Planning Application Ref: BE/63/17/OUT (4) **Current Comments in blue typeface**

Location: The Cottage, Shripney Road, Bognor Regis

Description of works: Erection of 21 new houses and flats with access and parking and landscaping.

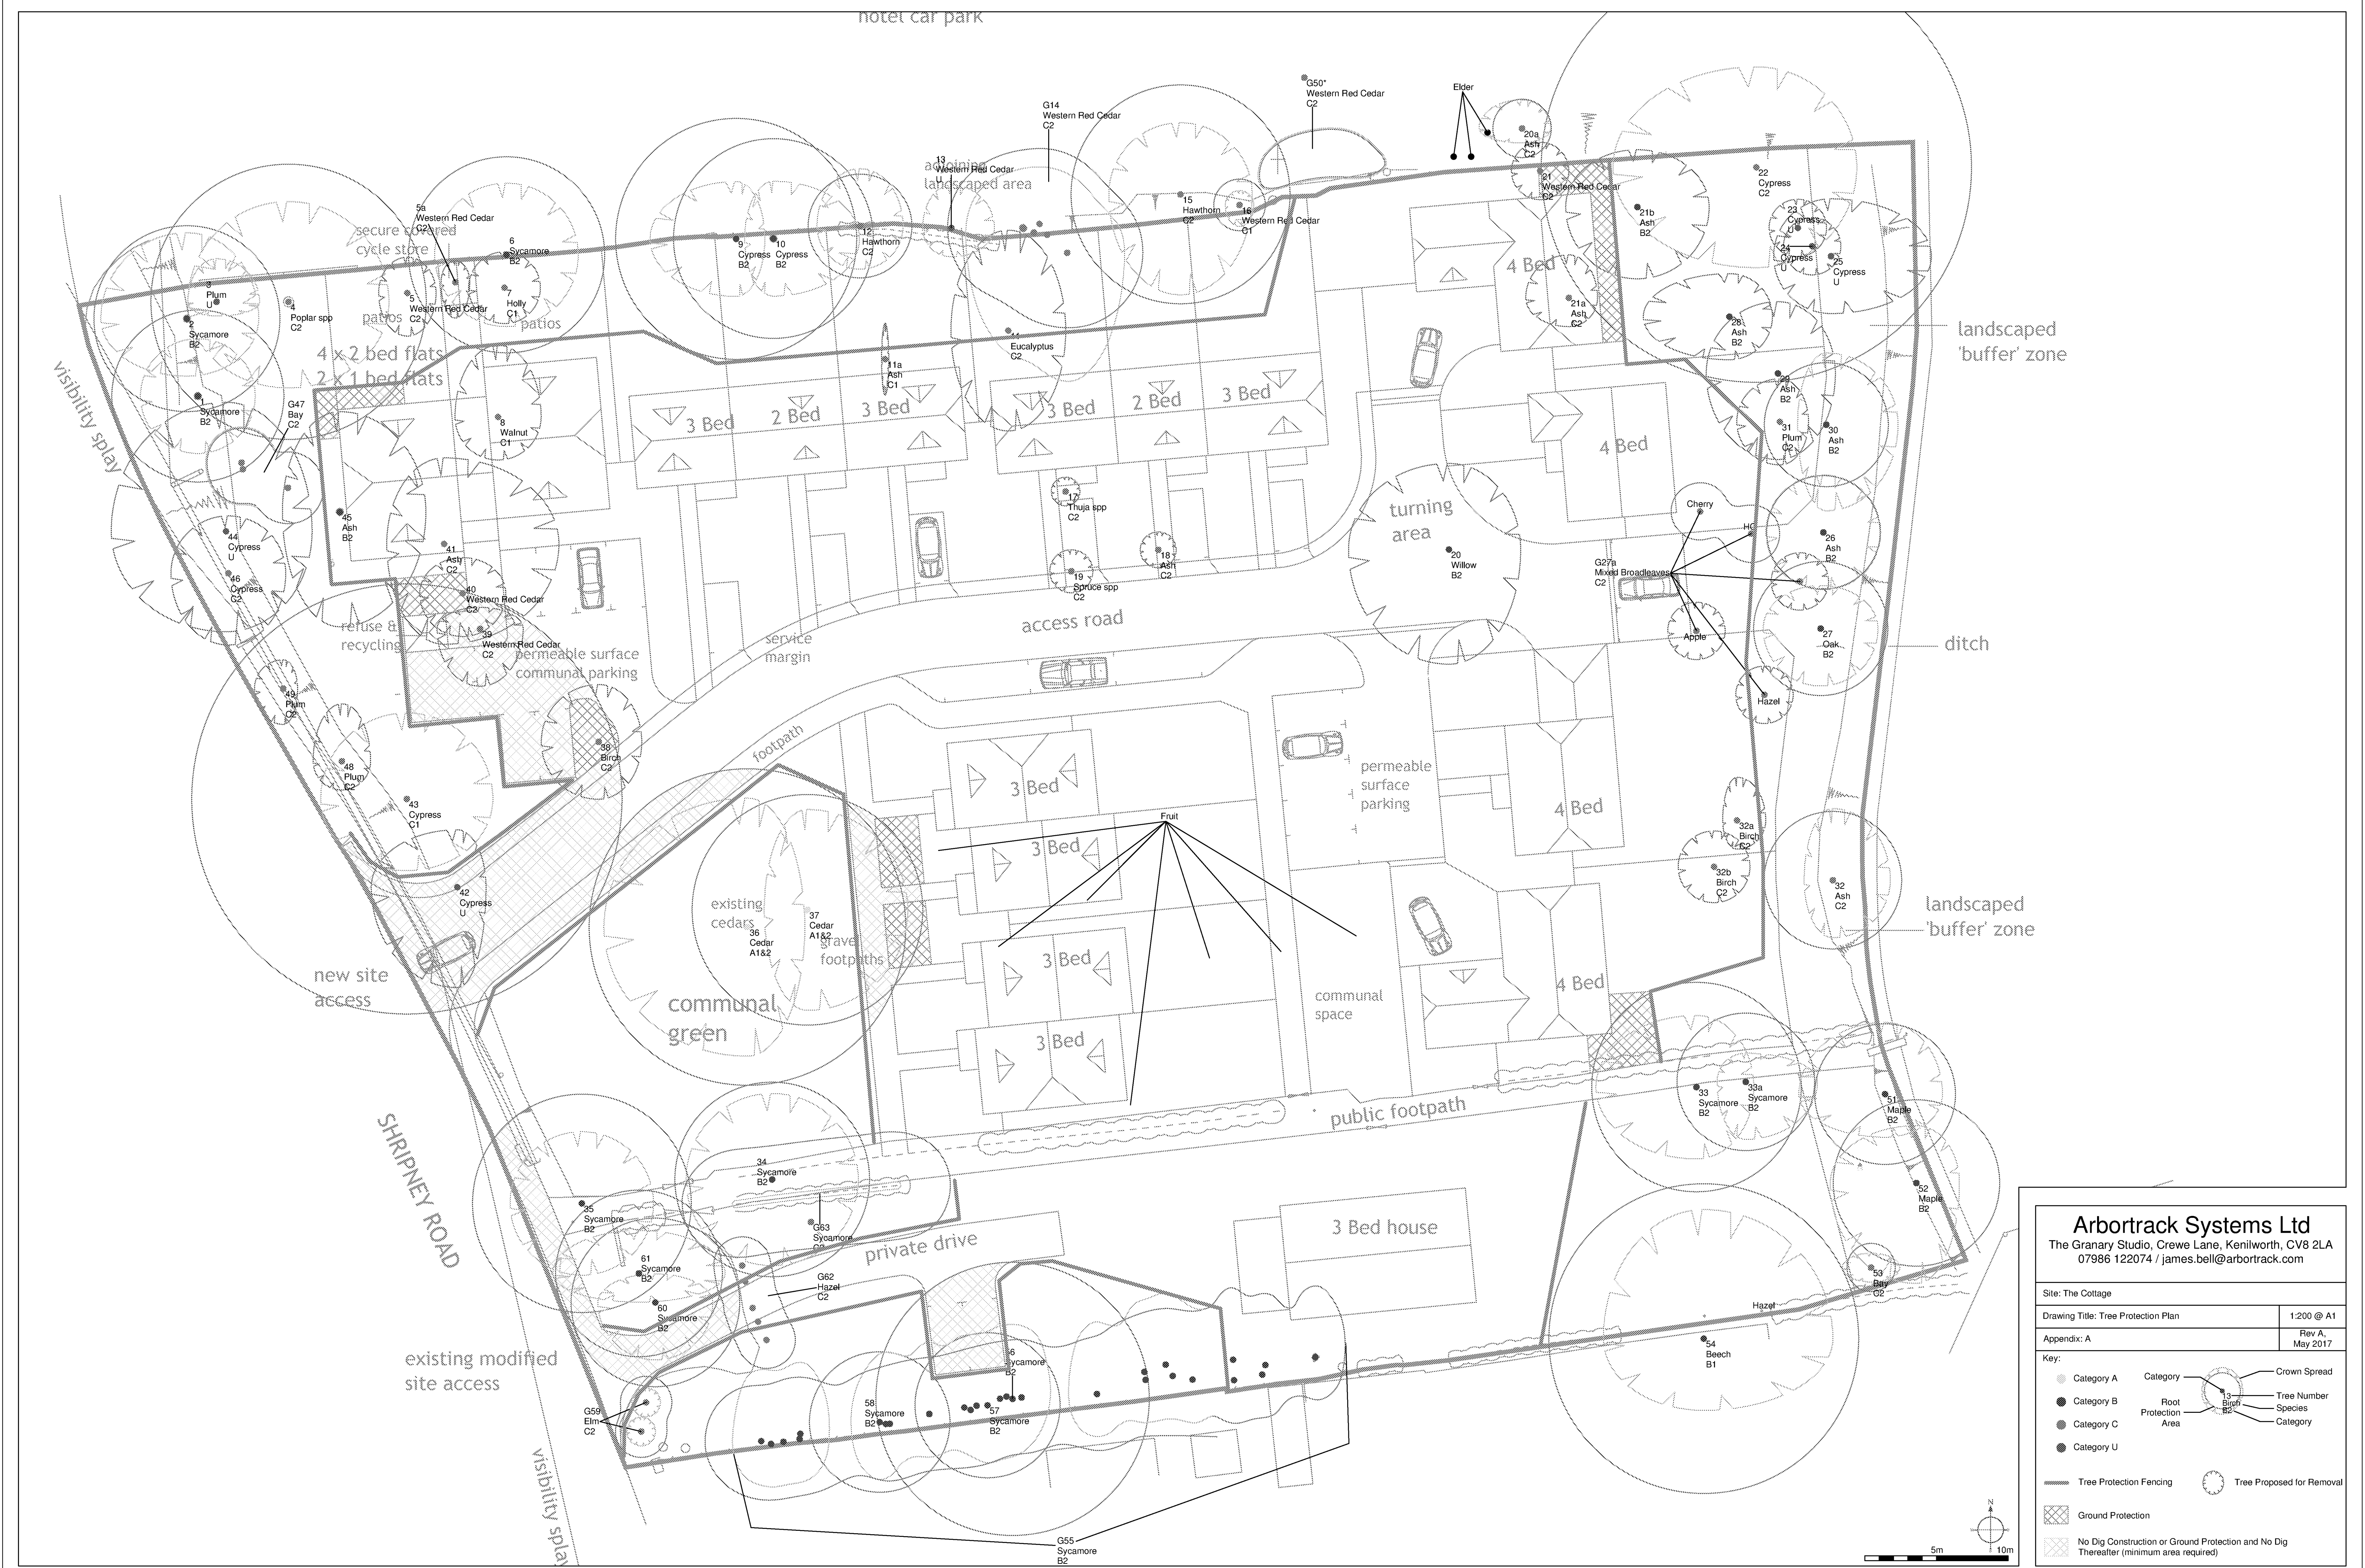
- My only remaining concern on this scheme is the footpath link across the front of the site linking both access points – is this really needed as it cuts right through the RPA of TPO'd tree **Sycamore T35**? Can they not move the two parking bays to one side (east) and extend the current footpath to the east side of **T36/37 Cedars** to link to the isolated Plot to the south?

- If this final adjustment can be made then I would be able to lend the scheme my full support – as it stands I would have to sustain an **OBJECTION** because of adverse impact on **Sycamore T35**.
- **I recommend APPROVAL for this latest layout submission subject to the following Conditions being applied :-**

The latest set of plans Ref: 334_P_03C and Arbortrack Systems AMS Report & Tree Protection Plan Rev D Sept 2017 now address this point with a layout change.

1. **All demolition & construction works are to be carried out in strict accordance with :- Arboricultural Method Statement Report Ref: Arbortrack Systems Ltd. jwmb/rpt5/thecottage/PI and Tree Protection Plan ref: Rev D Sept 2017**
